CITY OF ALBUQUERQUE

RE: **Lamonica Shops** - 3510 Coors Blvd. SW
Grading and Drainage Plan for Building Permit

File: **P10-D005**
PE Stamps: **02-06 & 2-21-2014**

GRADING AND DRAINAGE PLAN

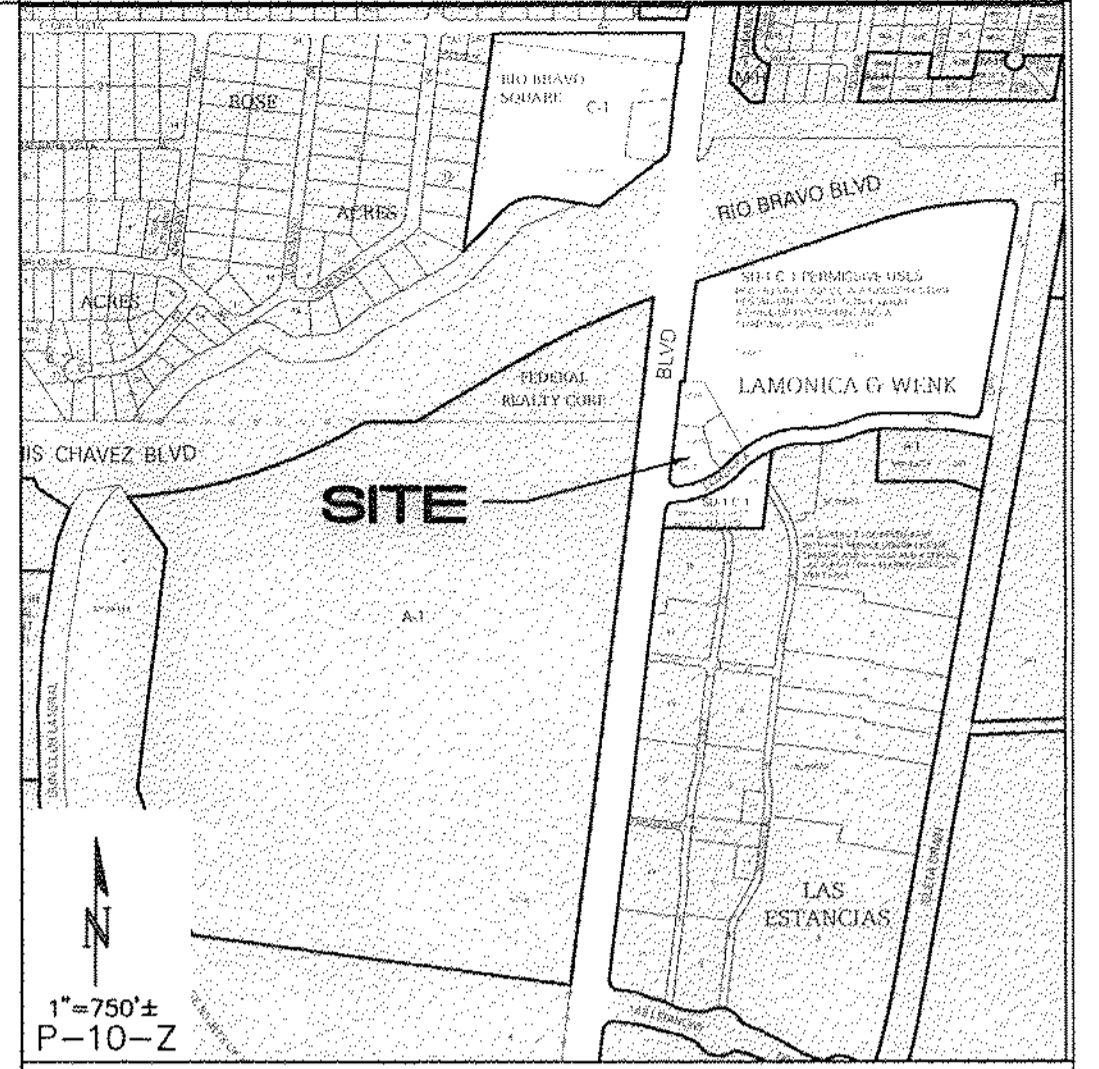
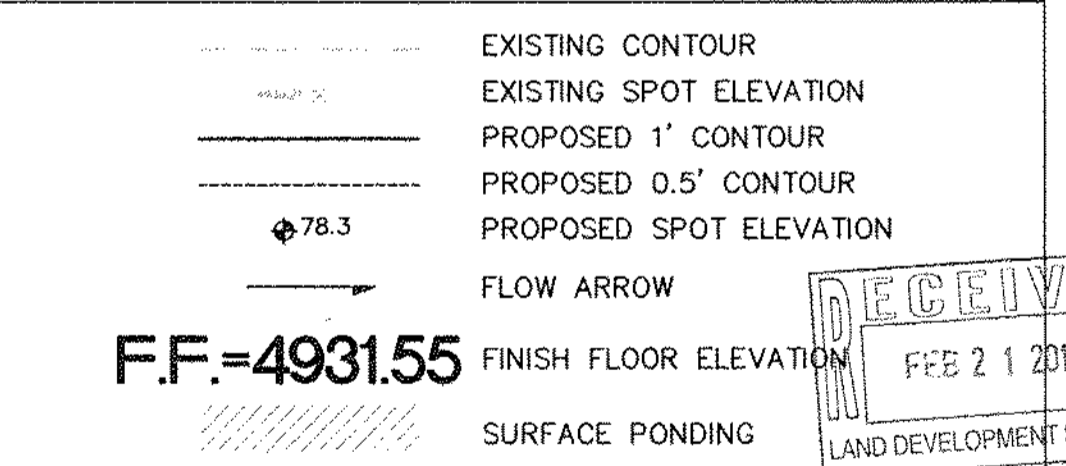
1. The Owners' statement and signature on the 2/21/14 plan, Sheet CG-101, needs to be amended to acknowledge that the relocation of the private drainage system from the easement will be "at the sole expense of the property owner."

2. Label each Detention/Retention Pond (limits shown) with WSE, Volume Required, Volume Provided, and orifice control size where applicable. Confirmation of these features will be required as part of the Engineer's Certification for CO.

3. The existing onsite drainage system and outfall pipe needs to be more clearly shown on the plan, including the Orifice Plate locations (with Q_{max}) and verified orifice sizes installed (not assumed) to provide the proposed detention for this development.

4. I am forwarding to you a scan of my marked up G&D Plan sheets to clarify information sought in items 2 and 3 above.
5. The ADS retention system needs to be more clearly dimensioned on the Grading Plan (not just referenced to ADS). In Section A, show the double fabric under the chambers and fabric wrap around the entire stone embedment. Provide the system dimensions on the cross section, as well as dimensions to the R/W, 14'-Roadway Easement, and face of building.

**1 SECTION A**

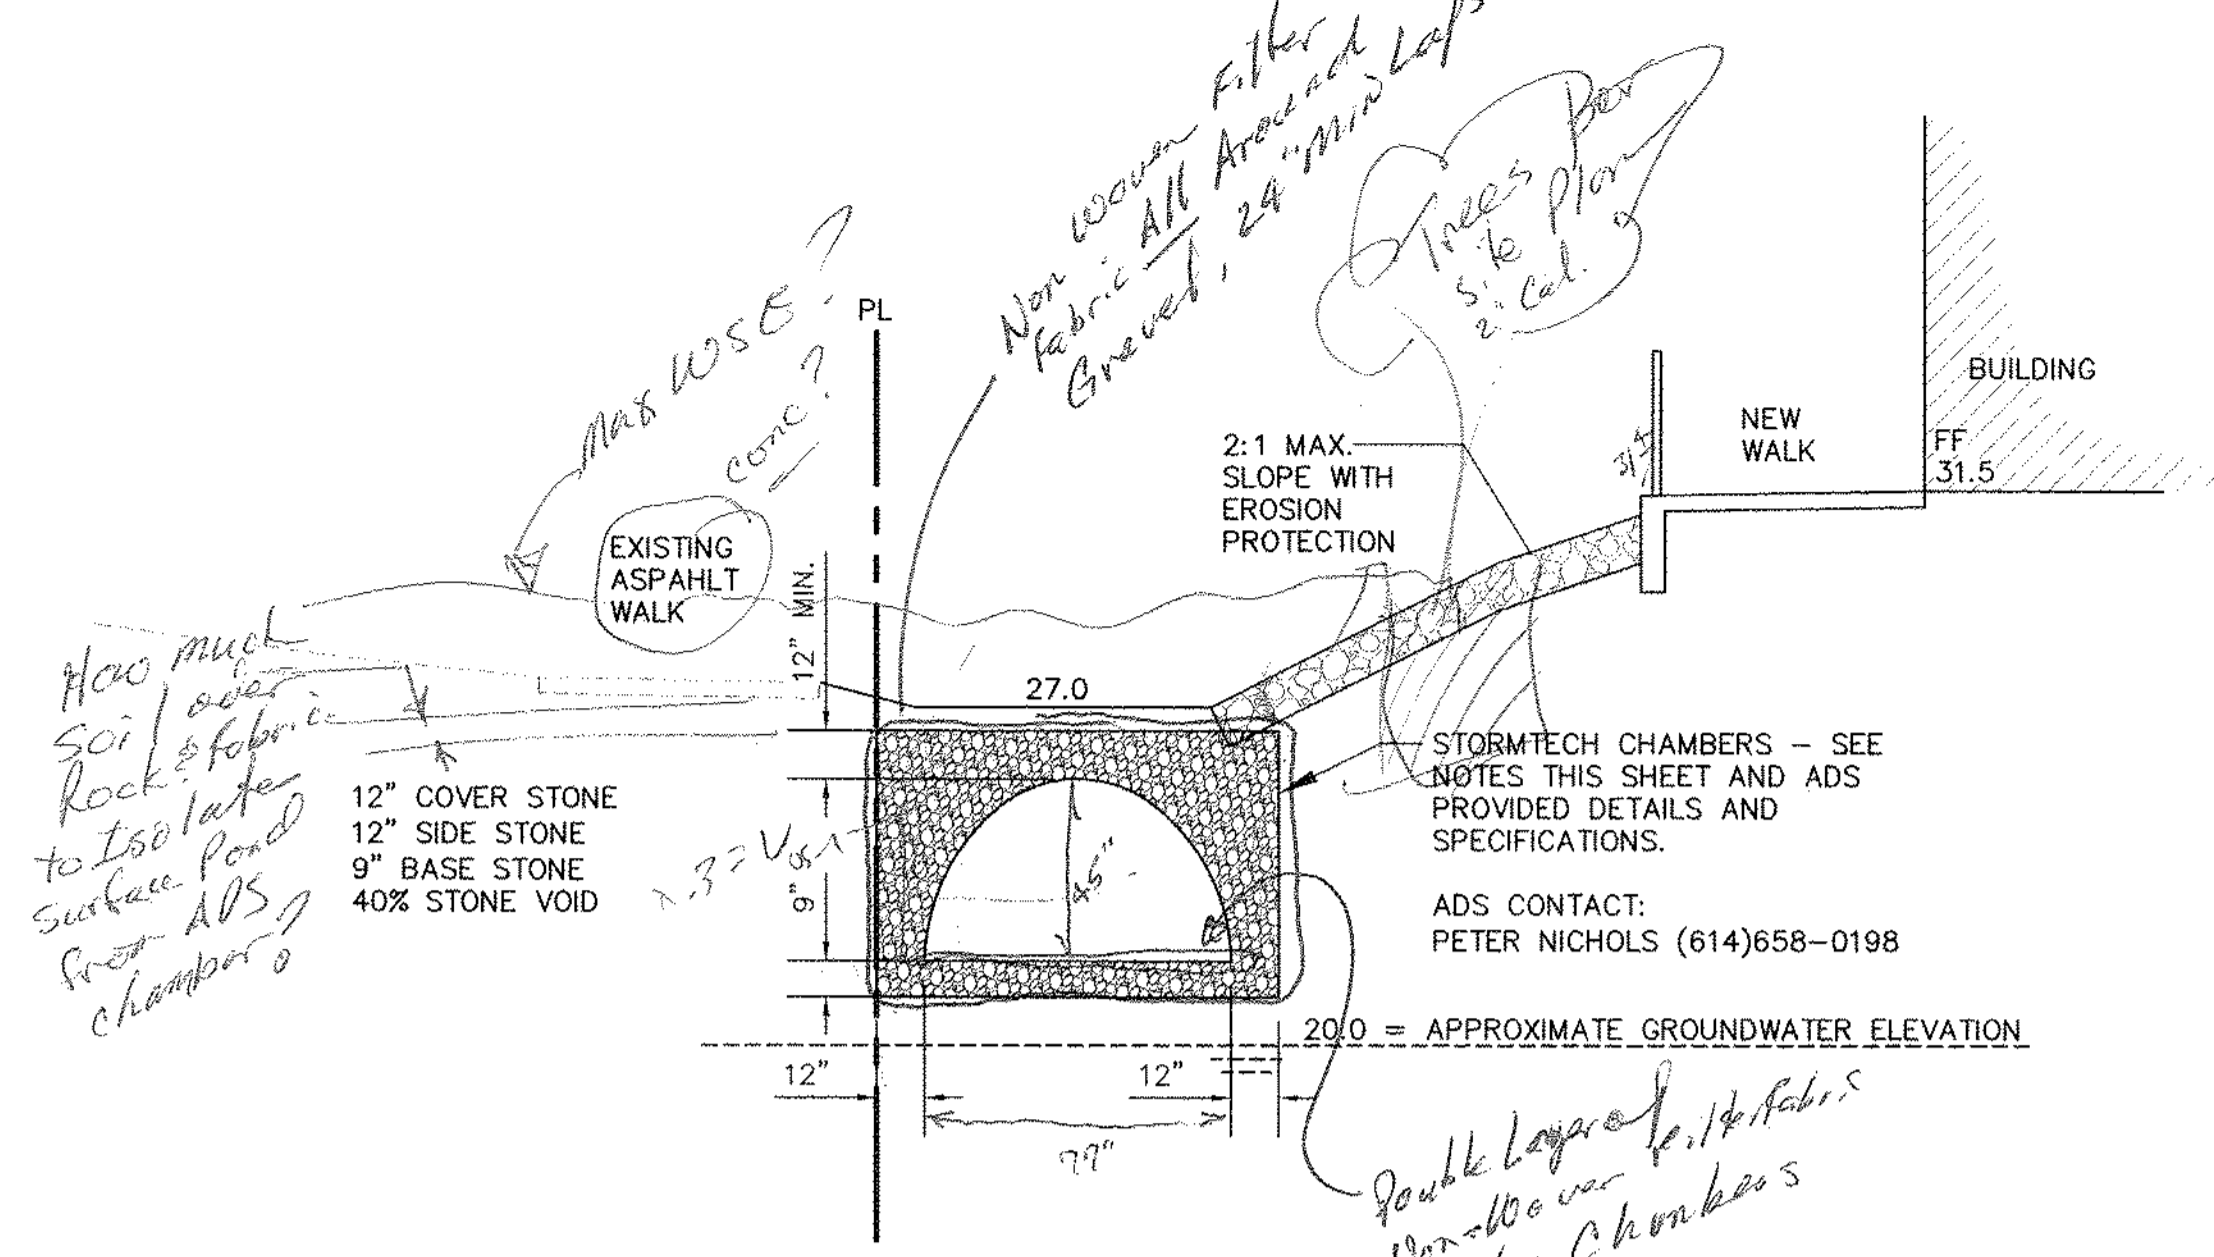
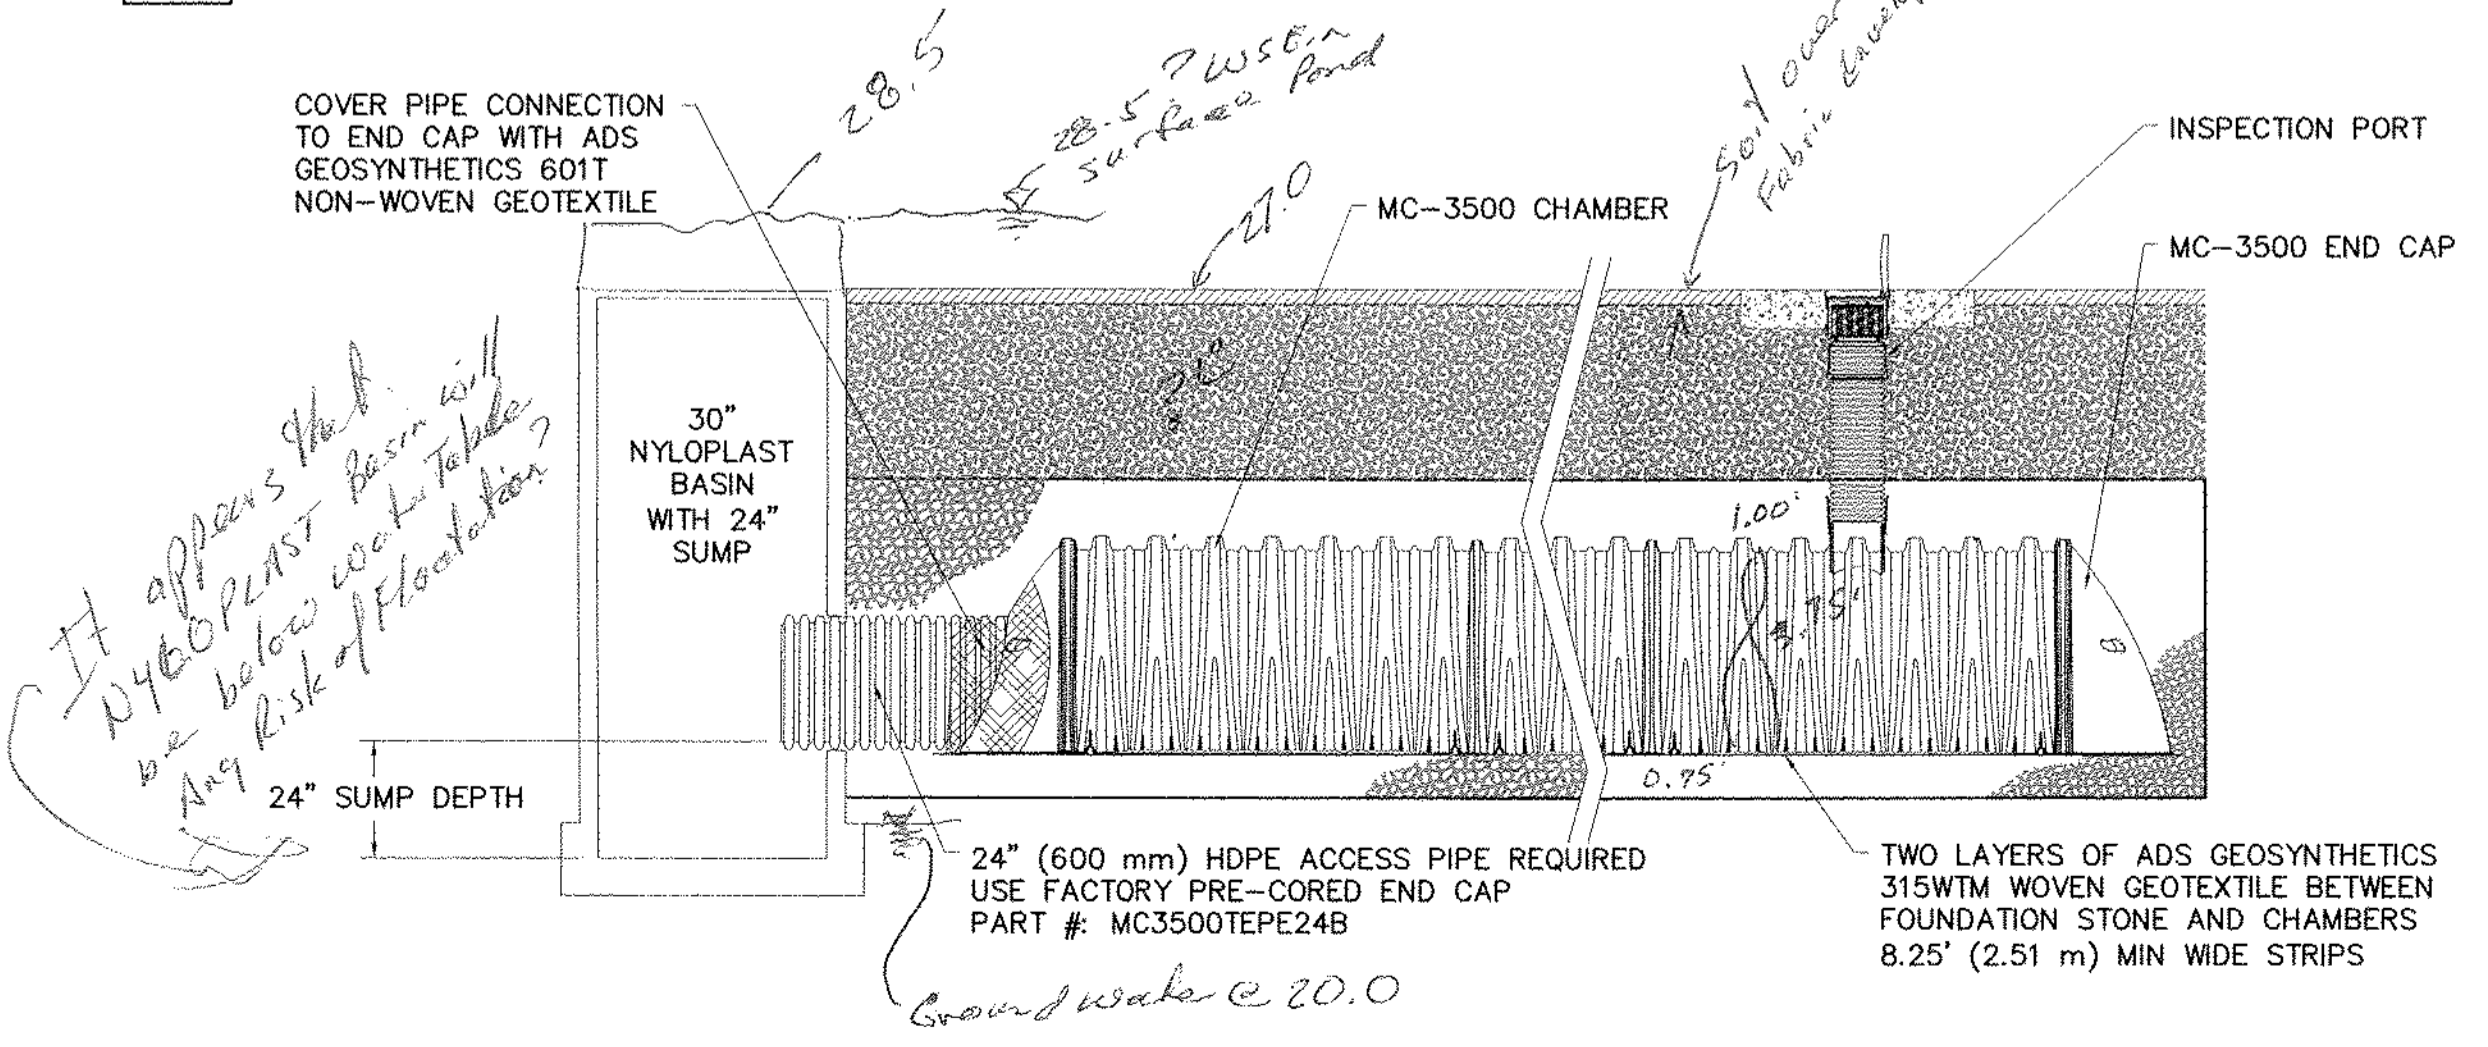
6. This Design uses a 40% void ratio on the stone embedment. We will only allow 30% voids, unless a local source for higher voids can be confirmed and specified.

My check of the volumes provided indicates that there is still enough volume at the 30% ratio to meet required volumes, but I'd like to see the 40% value removed from the plan, unless the local material meeting that level is available and specified.
Revise these plans accordingly.
